# STATE OF NORTH CAROLINA DEPARTMENT OF TRANSPORTATION

August 25, 2024

MEMORANDUM TO:		Division Environmental and Construction Units
FROM:	mat	Michael A. Turchy, ECAP Group Leader Environmental Analysis Unit
SUBJECT:		Environmental Permits for the Improvements to NC 150 in Catawba and Iredell Counties Division 12, <b>TIP: R-2307.</b>

SITE 10

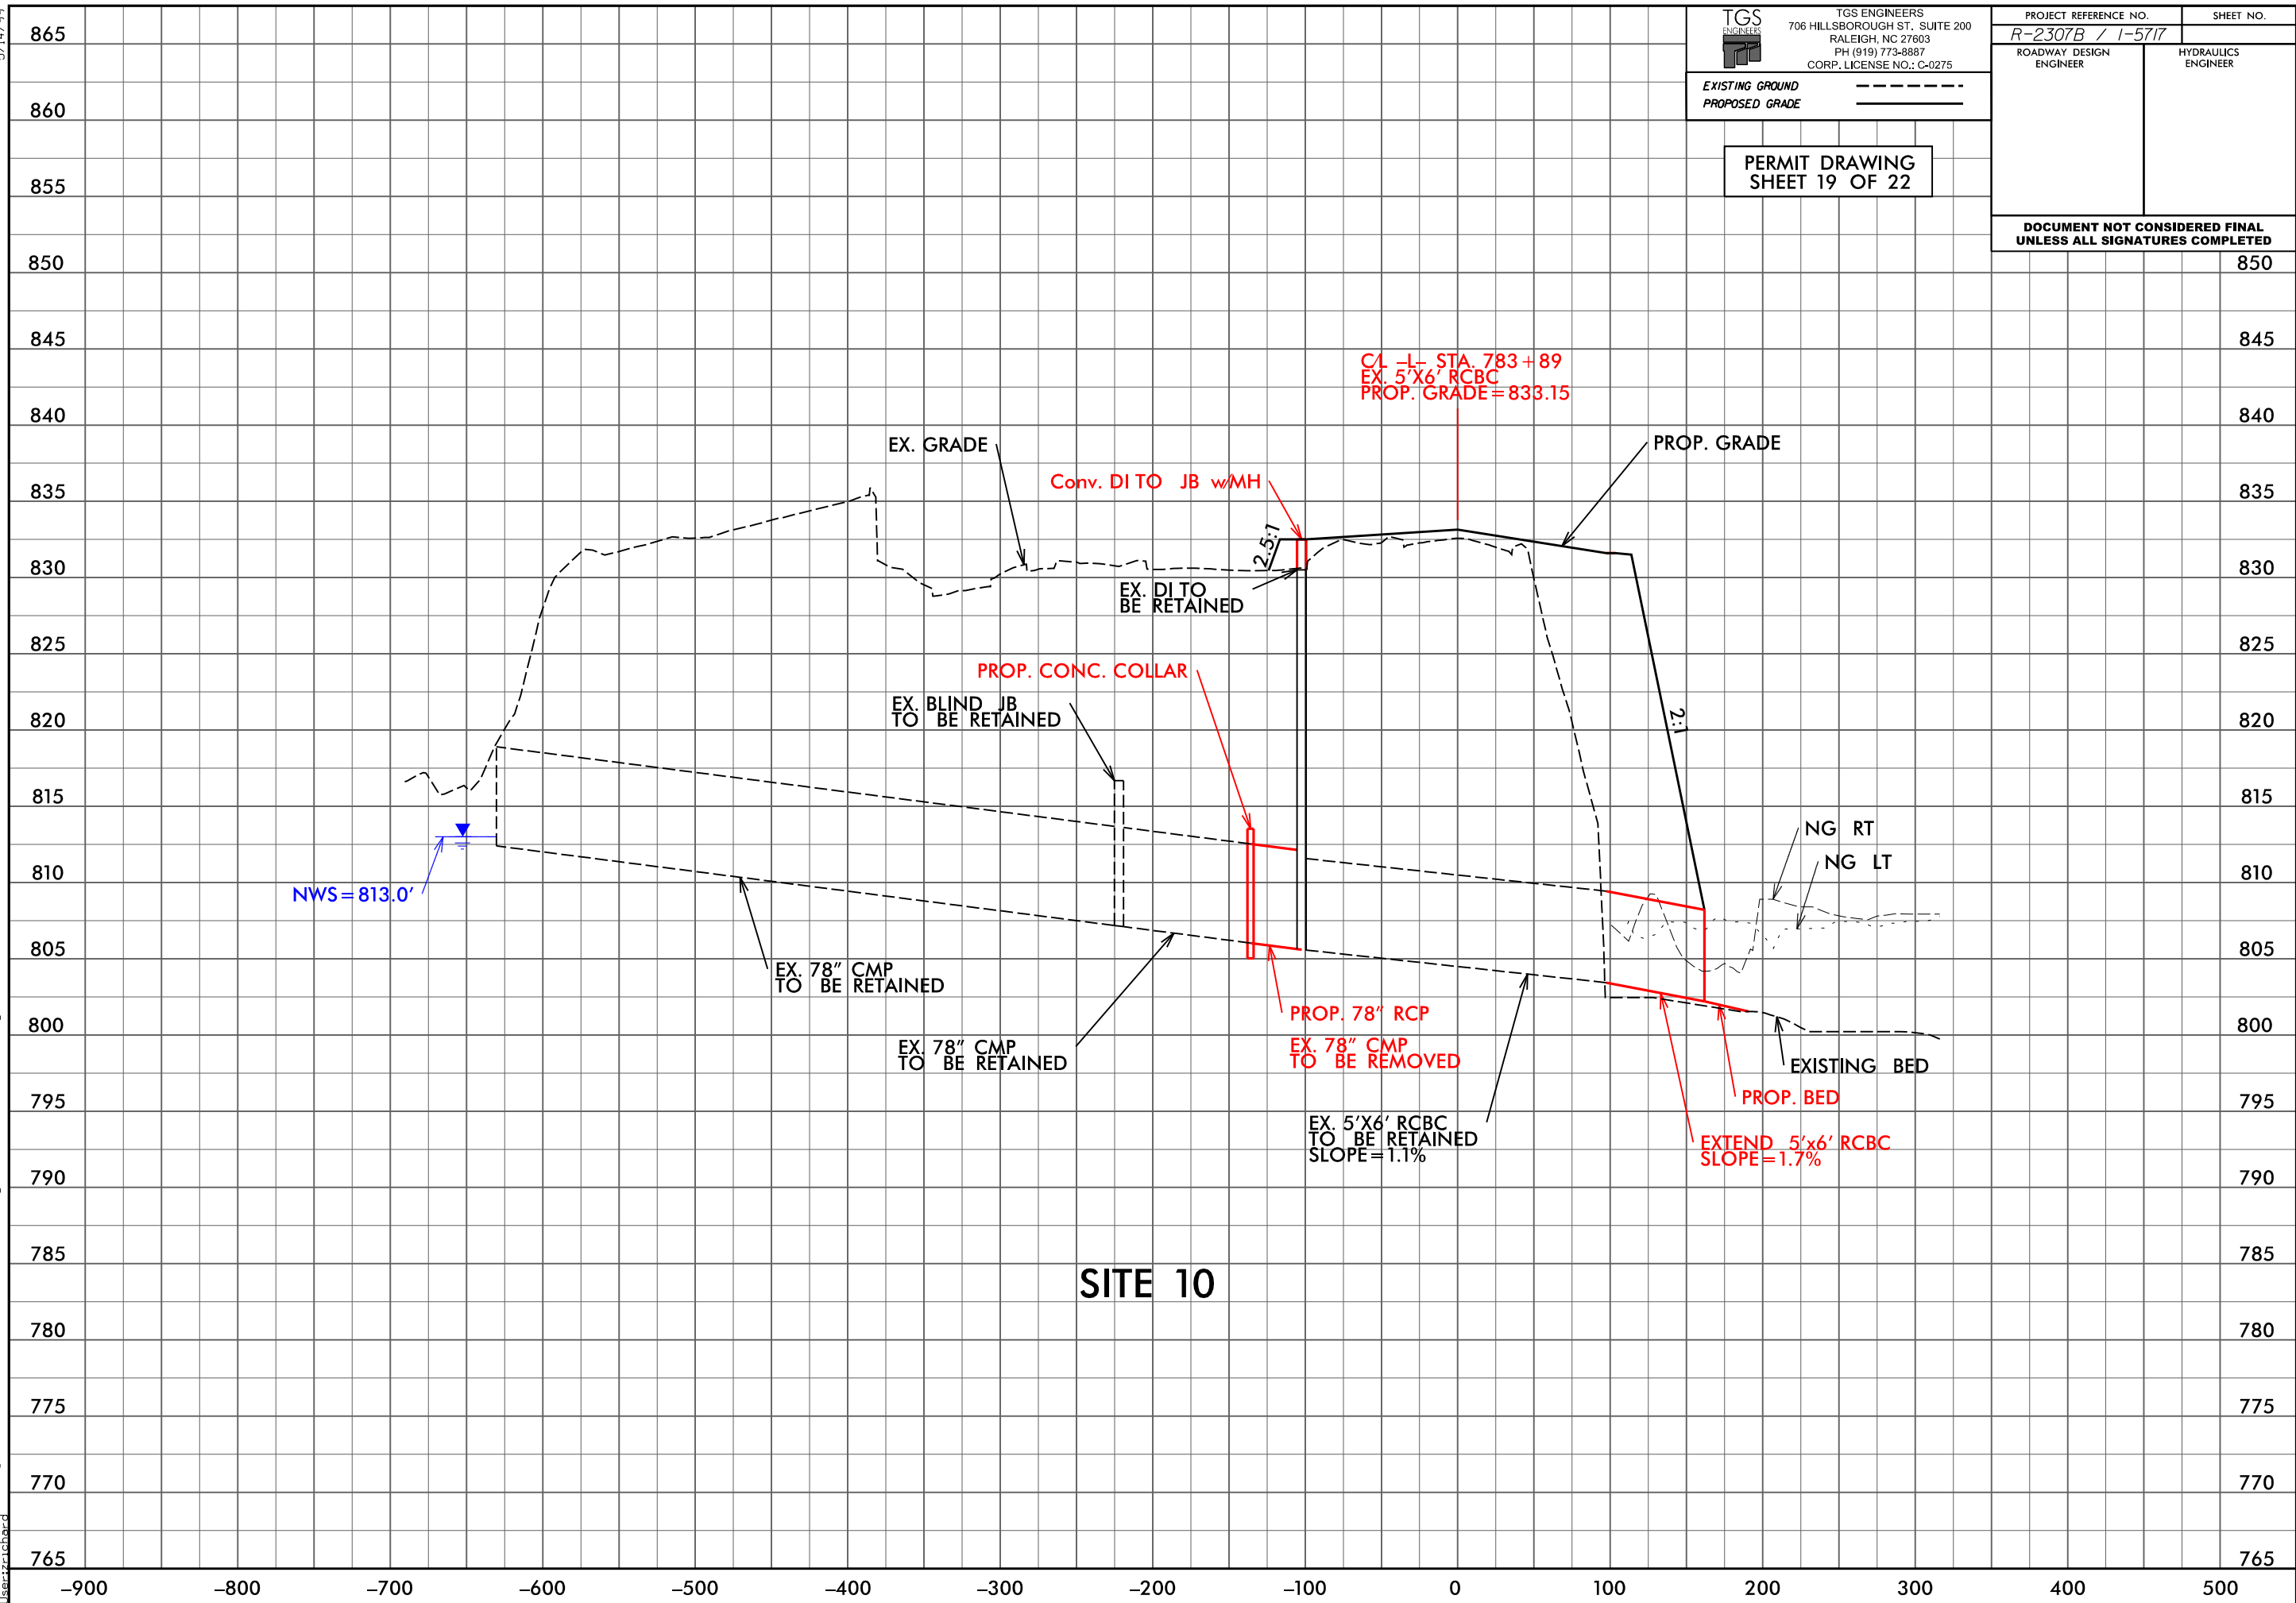
**Site 10**: The previous design proposed a 9' diameter precast manhole connecting an existing RCBC to a proposed 78" RCP at the downstream culvert extension at 784+50 RT (Permit Site 10). NCDOT determined that attaching a precast manhole to the existing RCBC is not feasible and would require a cast in place connection. To avoid this situation, the existing 5'W x 6'H RCBC will be extended. This will result in the outlet of the RCBC shifting 3' west of the previous 78" RCP outlet. However, the inverts, lengths, and channel layout will remain the same. There are no changes to stream impacts.
